Fw: Planning Consultation on: LU/141/26/DOC

Please find attached the revised drawings, updated drainage calculations and the designer's response addressing the two comments:

I'm contacting in respect of application LU/141/26/DOC to discharge Condition 10. We have received the attached consultation response from the ADC Drainage Engineers. They are requiring further information be submitted before they can recommend approval. Please could we request that you review the attached, and provide the required information to us by **27th July**.

Drawing file: LU_141_26_DOC / 519.1.VCE.0511 T3 - Longitudinal Sections.pdf

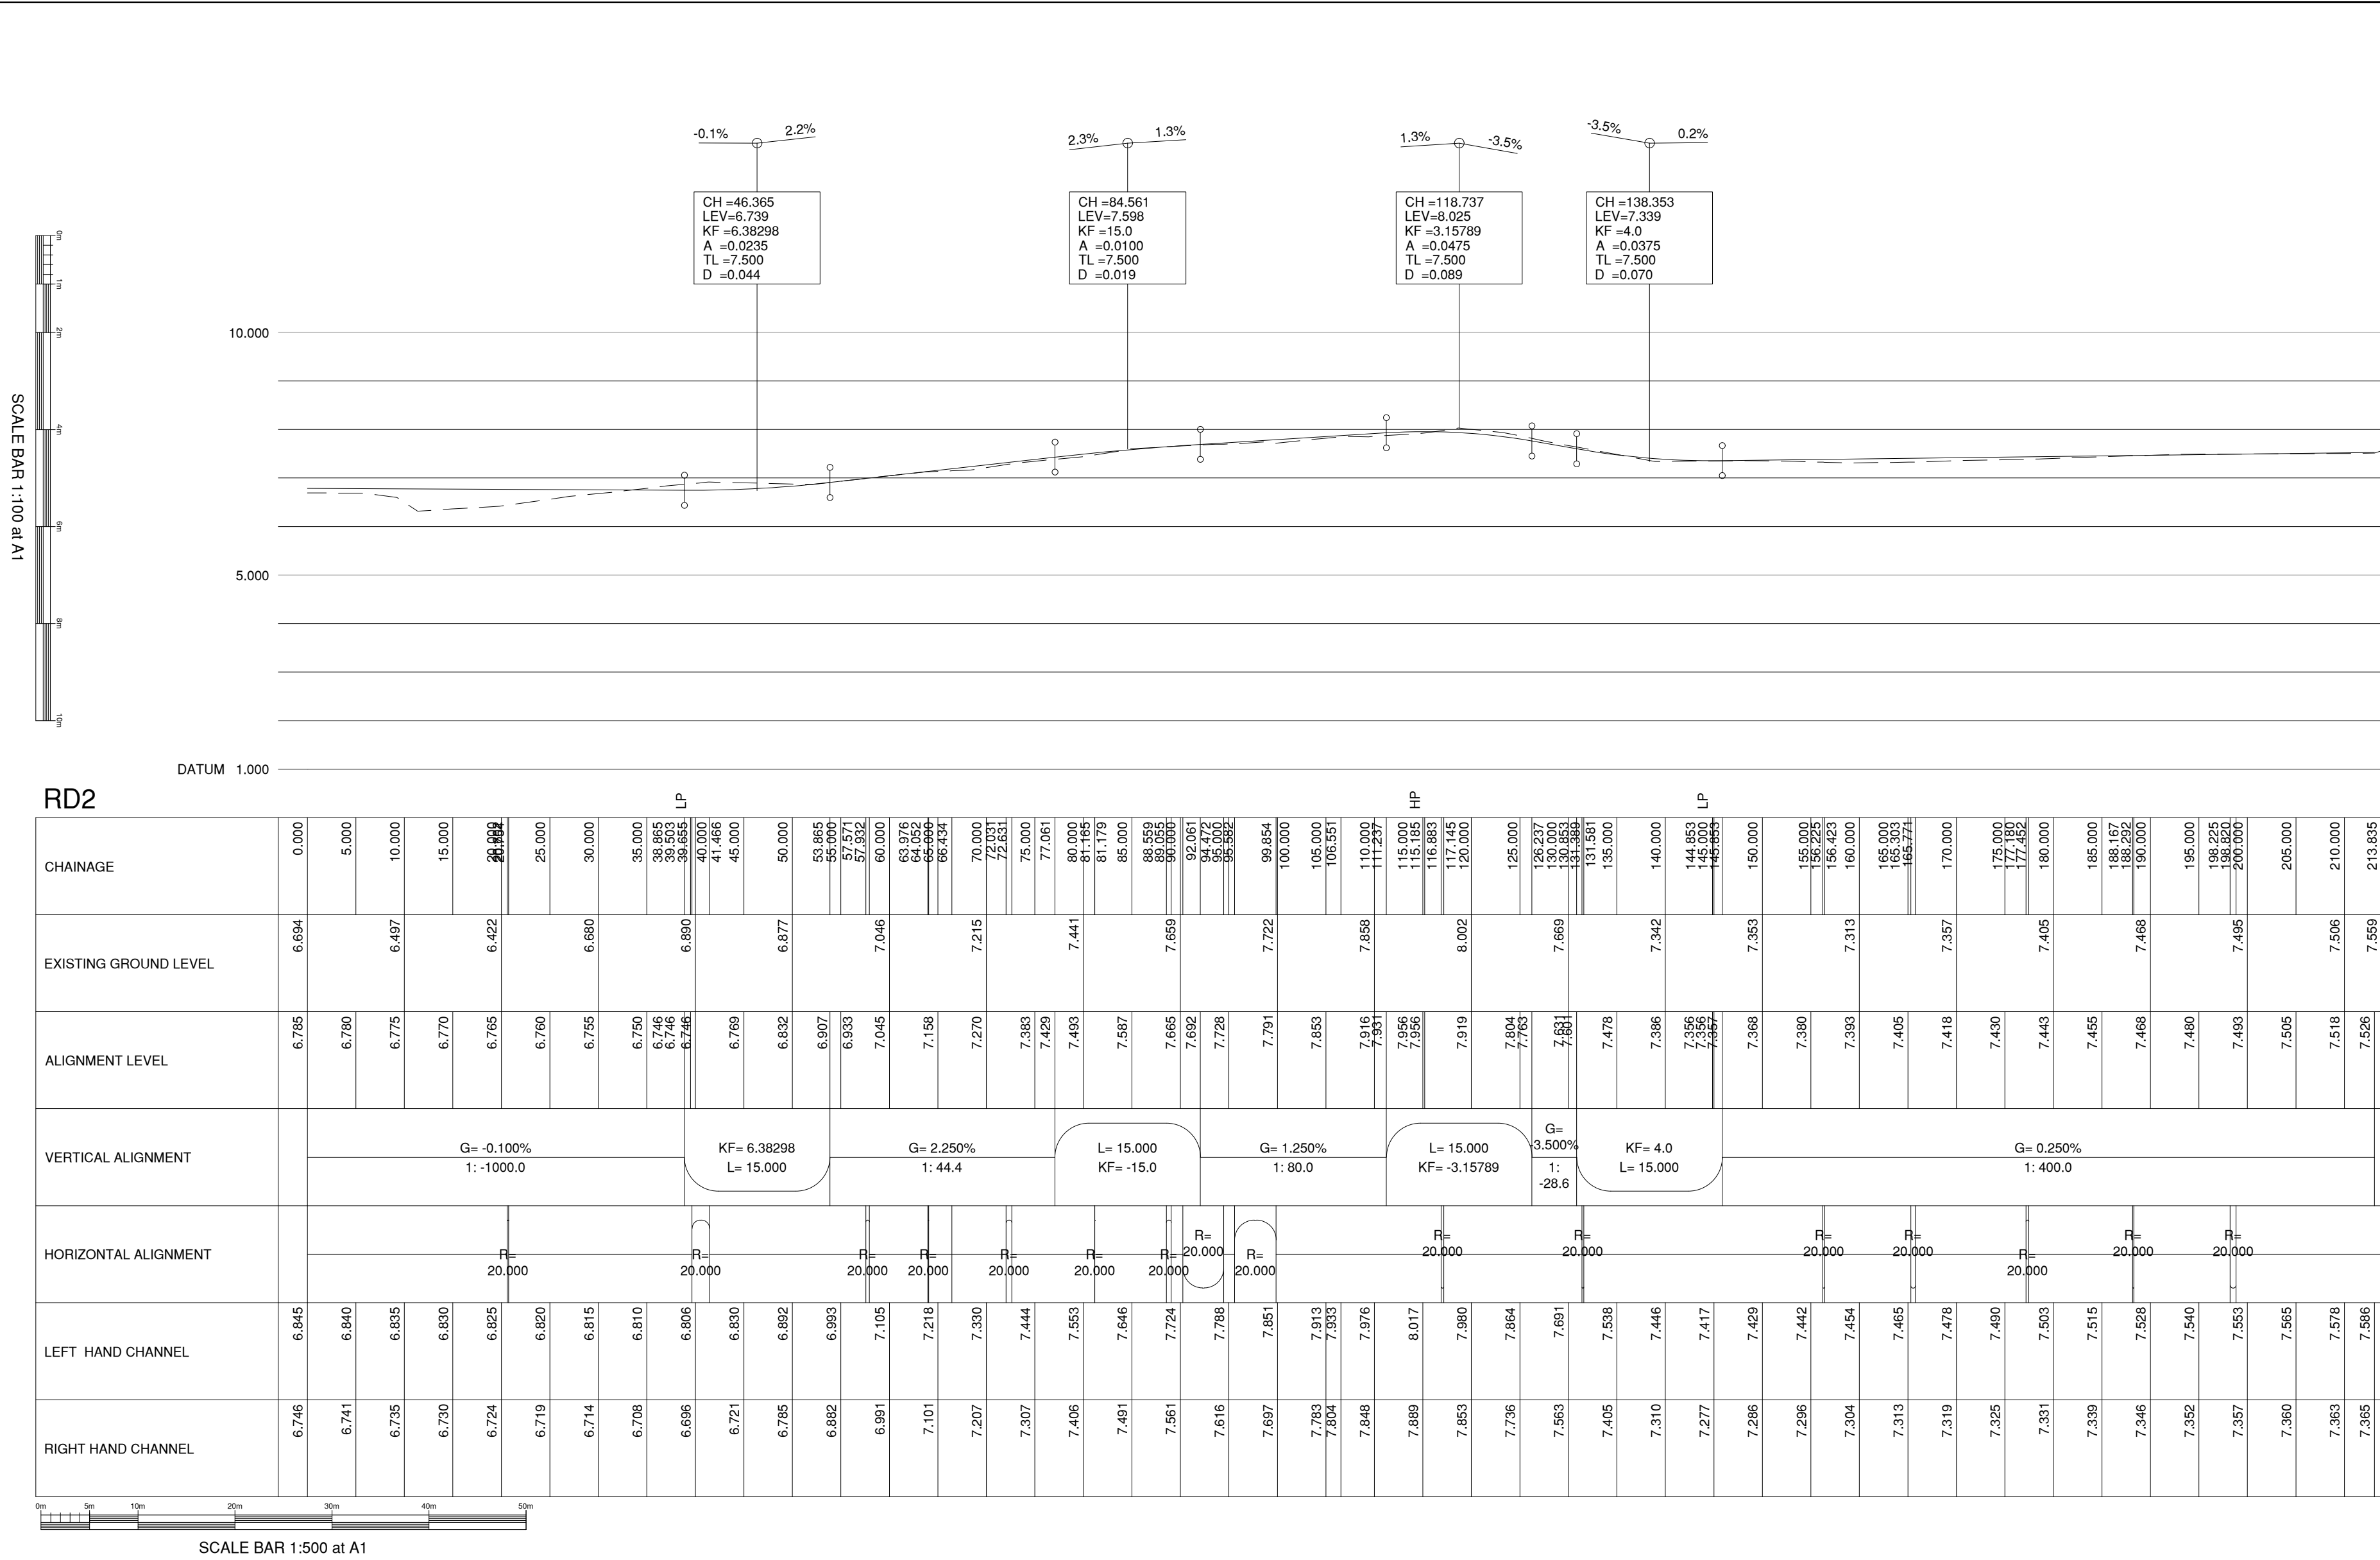
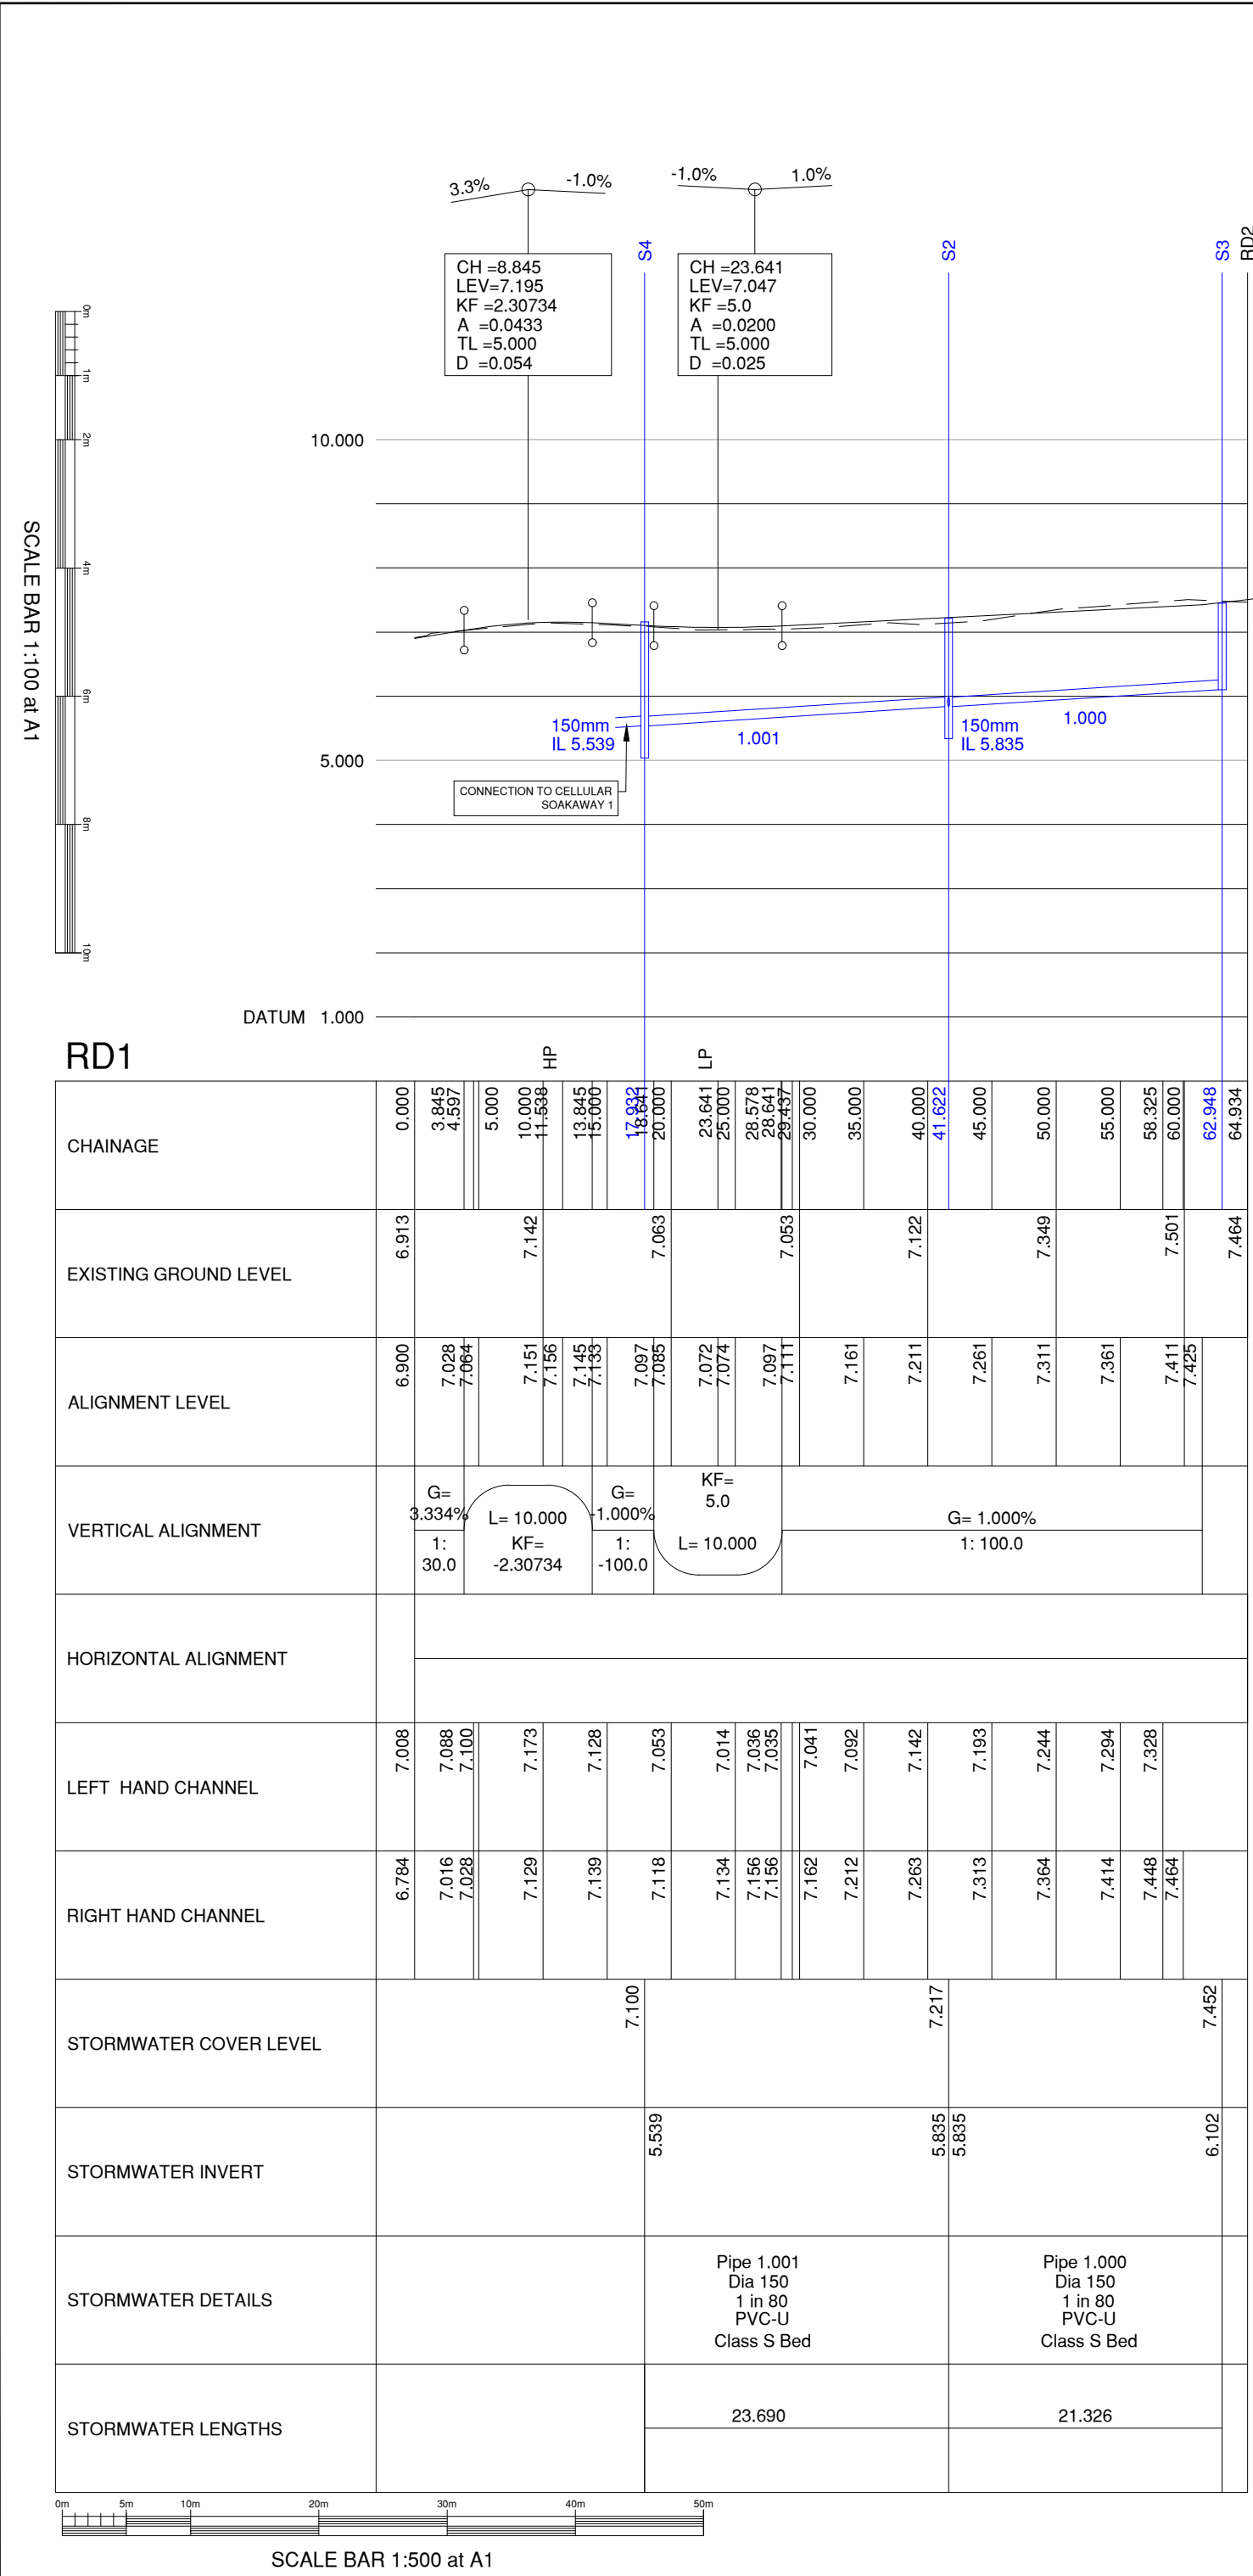
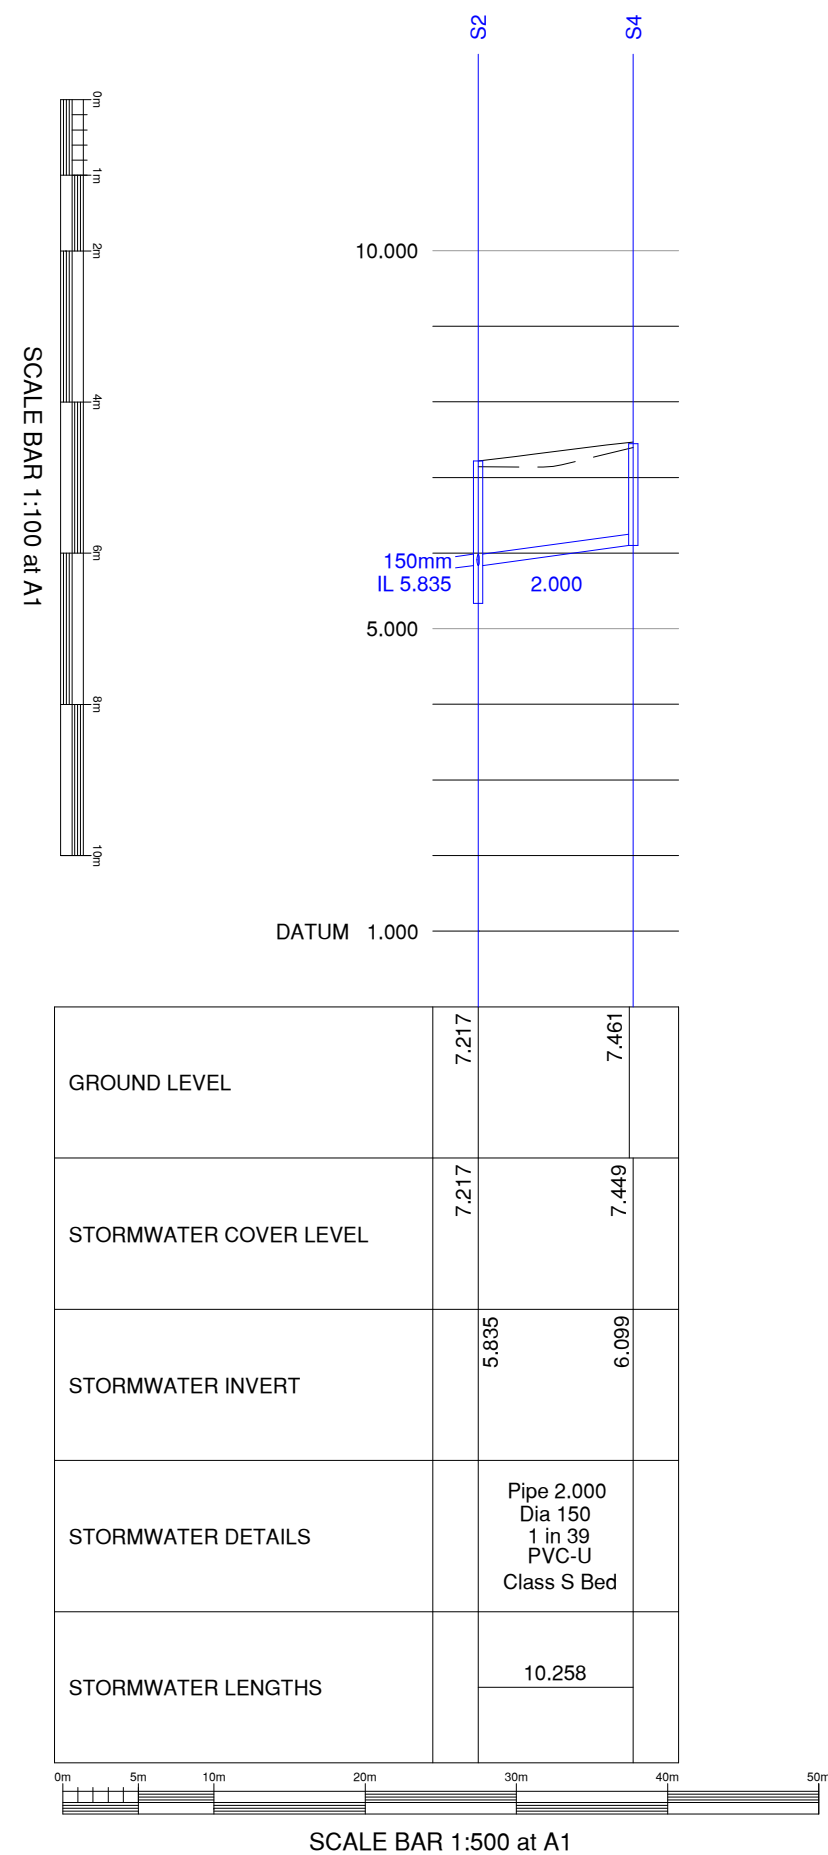
- The calculations have been re-run with the MADD factor set to 0m³/ha, as requested, however, this has not made any significant difference to the results.
- The other comment relates to the separation between the soakaway base and the highest recorded groundwater level. The previous detail referred to both a min. 1.0m separation and a 400mm penetration into the River Terrace Deposits. When the levels are worked through, the 400mm penetration gives a separation of 930mm rather than 1.0m. This was previously left as shown because the difference is only 70mm, the cover level at BH1 is interpolated, and raising the soakaway base to achieve the full 1.0m separation would mean the required half-drain time is no longer achieved. In practical terms, it is a choice between a marginal reduction in separation and a soakaway that does not meet the required hydraulic performance.

NB: The attached ZIP only contains the revised drawings and calculations. The only design change is a minor adjustment to the soakaway base level, as explained above.
